KIRKLEES METROPOLITAN COUNCIL INVESTMENT & REGENERATION SERVICE

DELEGATED DECISION FOR DISCHARGE OF CONDITION AA.2(3) - NOTIFICATION OF ENLARGEMENT OF A DWELLINGHOUSE BY CONSTRUCTION OF ADDITIONAL STOREYS

Reference no. 2024/CL/91465/W

Site Address 1, Viewlands, Fixby, Huddersfield,
HD2 2HY

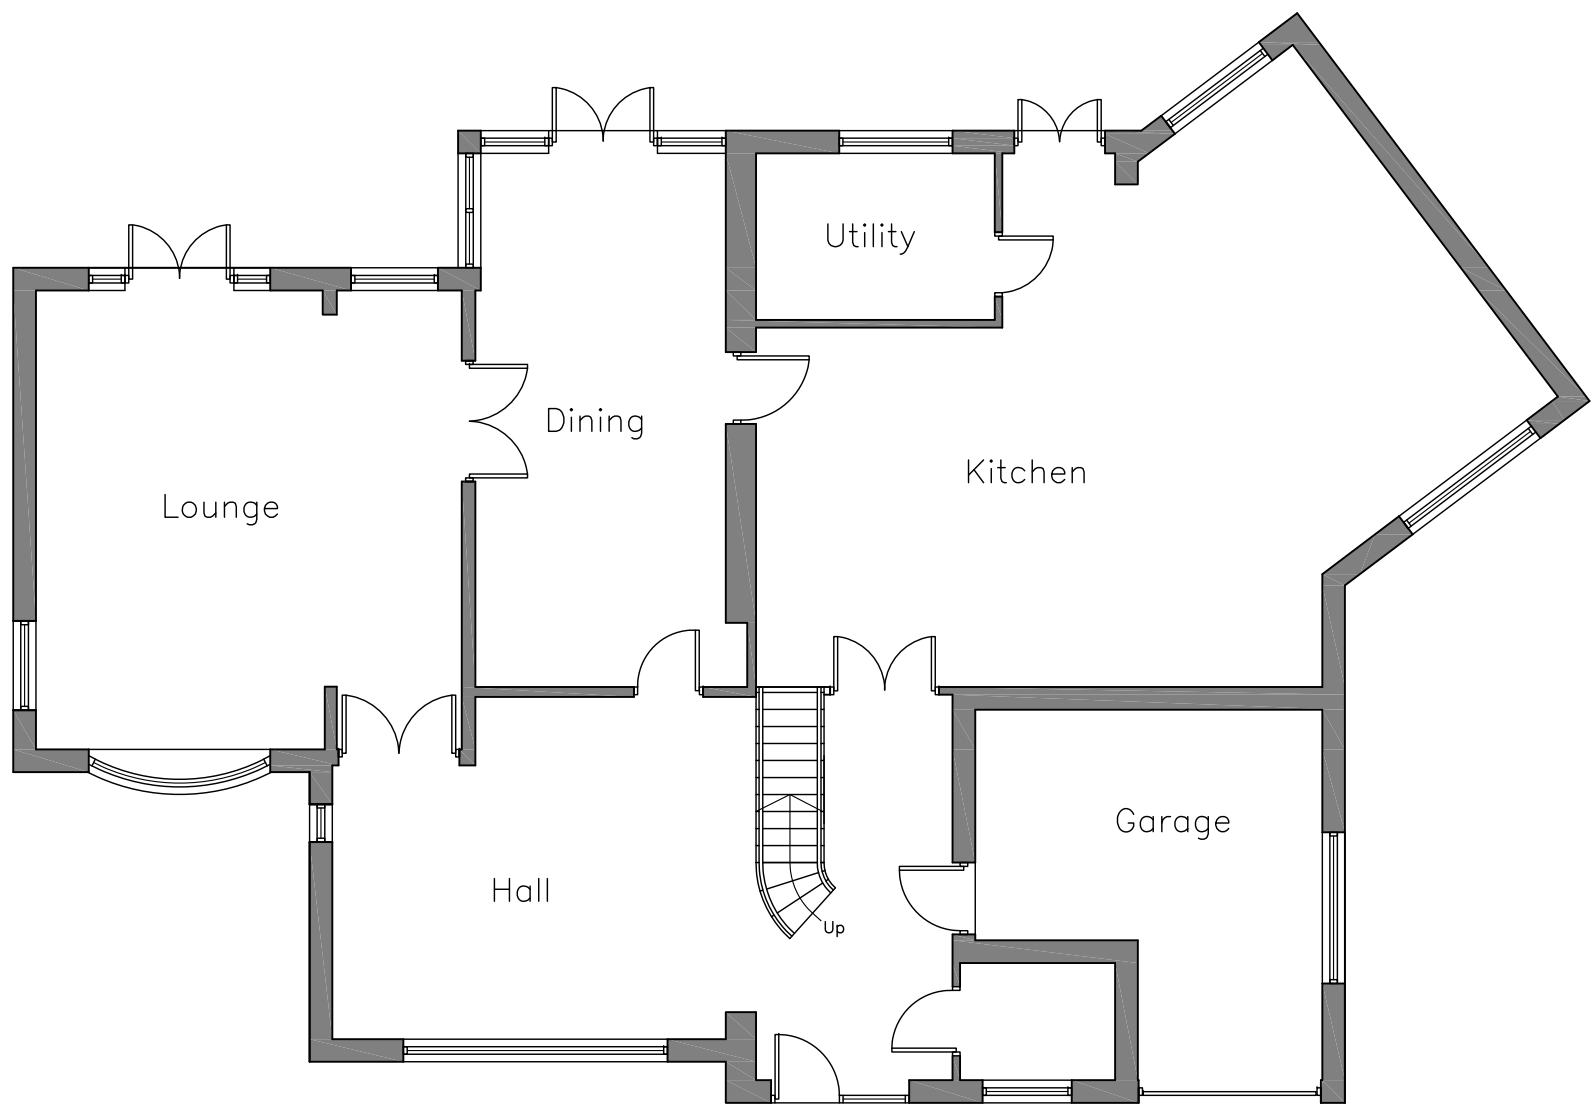
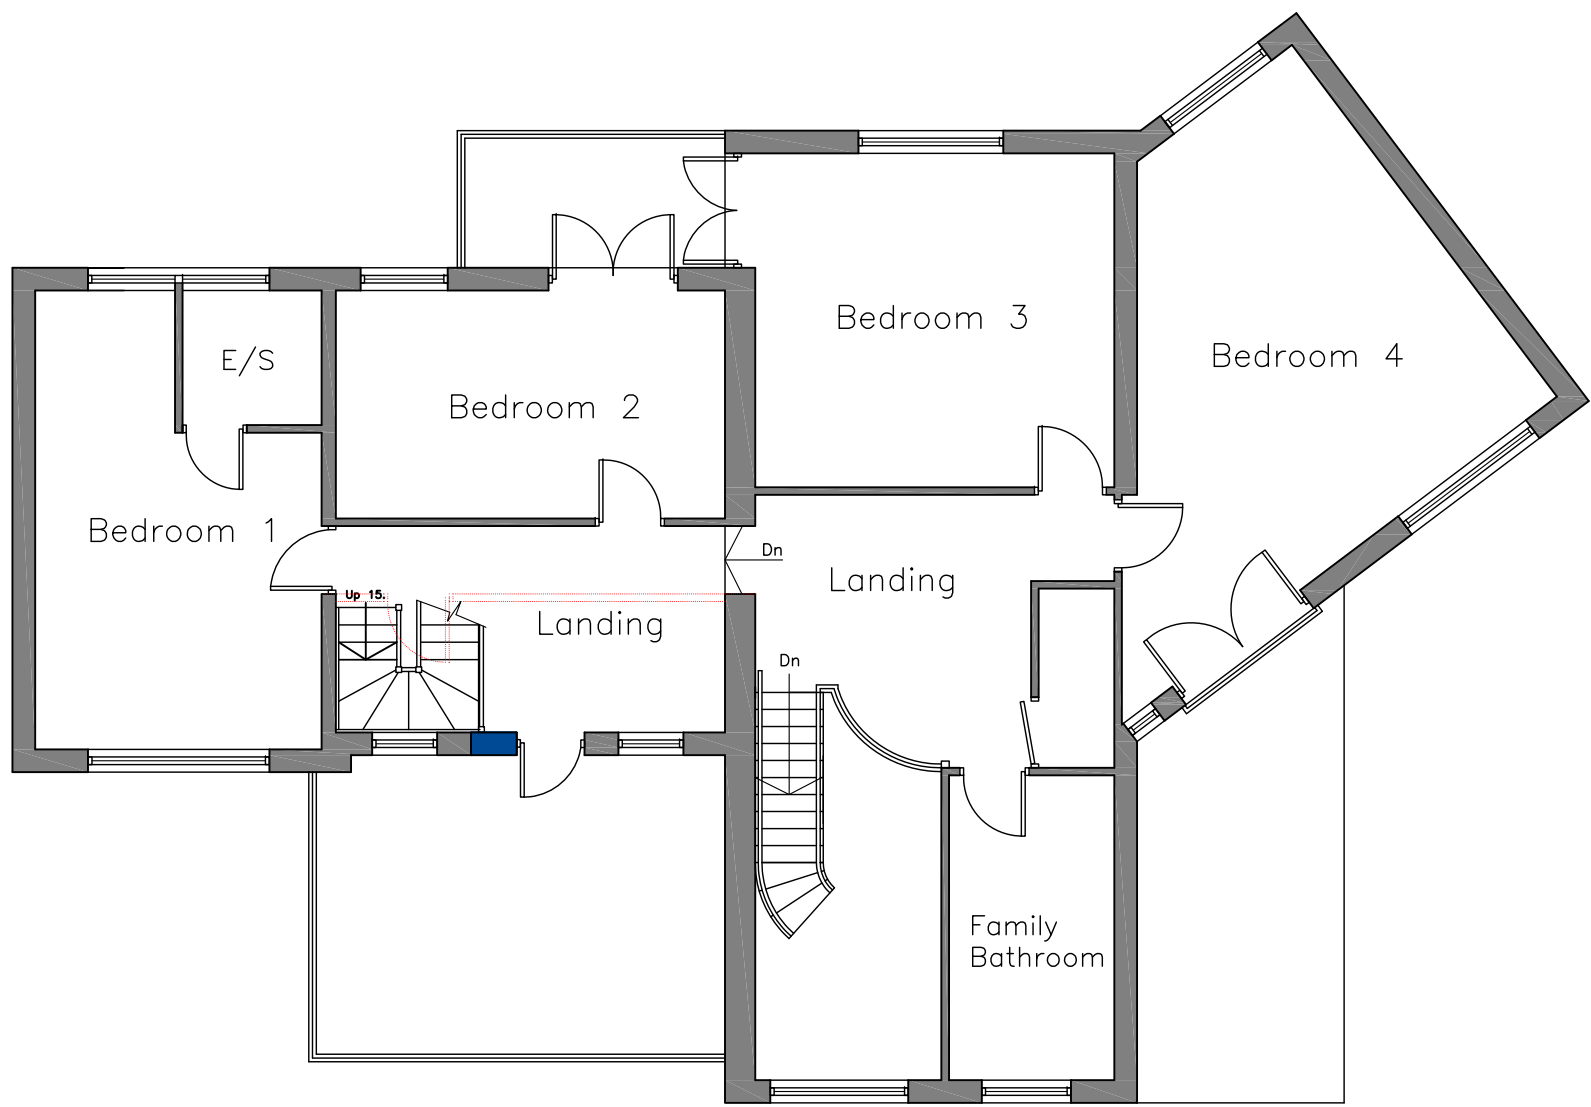
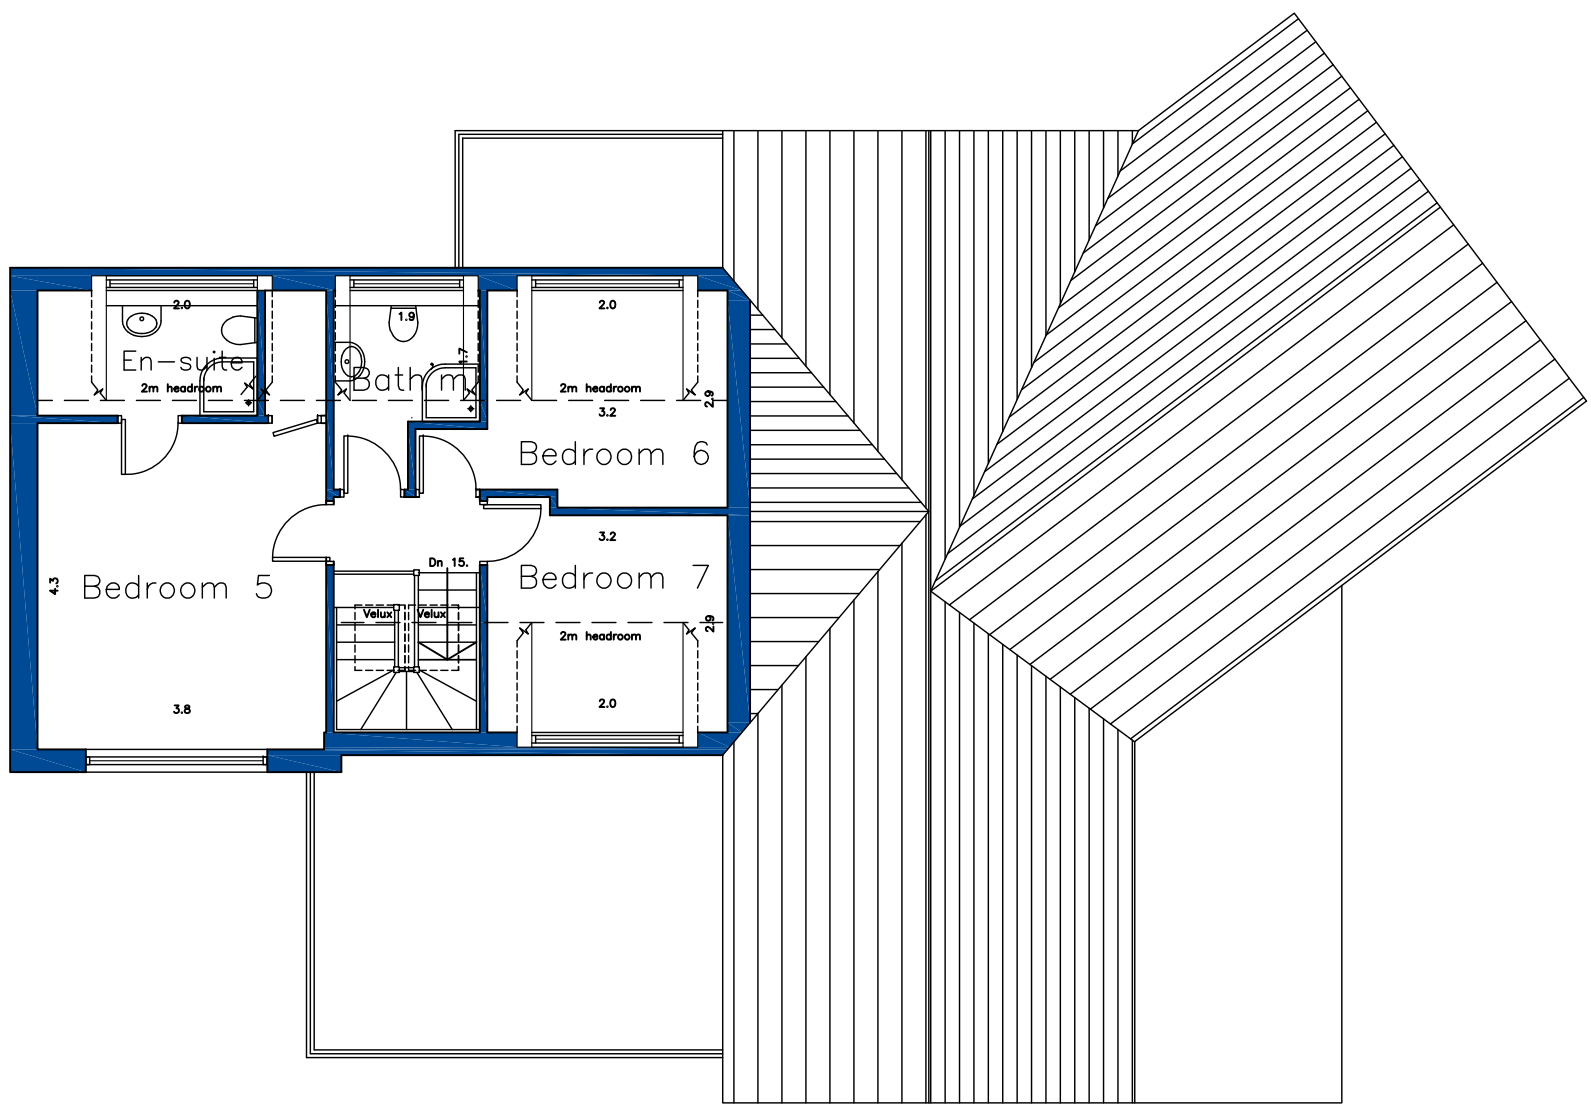
3.1 It is proposed to add an additional storey to the part of the original building. The drawings indicate that the eaves height and overall height of part of the original building would be raised to correspond with the same roof angle as the existing.

3.2 The plans shows that openings would be created within both the front and rear elevations at second floor level and dormer windows would be located within the front and rear elevation roof slopes.

- 9.4 The increase in height would be above the original main body of the property with adjacent neighbours surrounding the property. Officers consider that raising the ridge and eaves of the dwelling by 1.5 metres would slightly increase the existing overshadowing in winter months during the morning and evening hours when direct sunlight is limited.

- 9.5 New openings would be introduced within the roof slope of the rear elevation and within the roof slope and 2nd storey of the front (south facing) elevation however as there are window openings at first floor in the dwelling, the new windows would not offer any significant effects that would lead to loss of privacy or overlooking into neighbouring gardens. The openings within the rear elevation are screened from the neighbouring property to the north by trees.

9.11 In terms of the impact of the scheme on the external appearance of the principal elevation of the property, in this instance this would include openings being included within the second storey and roof slope of the principal south facing elevation and within the roof slope of the rear elevation. No consideration can be made to the impact of the rear elevation of the proposal as consideration can only be given to the principal elevation and the side elevation fronting a highway which is the west facing elevation in this instance. The openings within the principal elevation would be aligned with the openings at first floor and are therefore considered acceptable and consistent with Local Plan Policy LP24 and advice within the NPPF.

9.12 The side elevation of the property would also face a highway and is therefore also required to be considered. The proposed side elevation contains no additional openings. Condition AA.2 (2) (b) states that"the development must not include a window in any wall or roof slope forming a side elevation of the dwellinghouse;" . As none are proposed, the proposed meets this test.
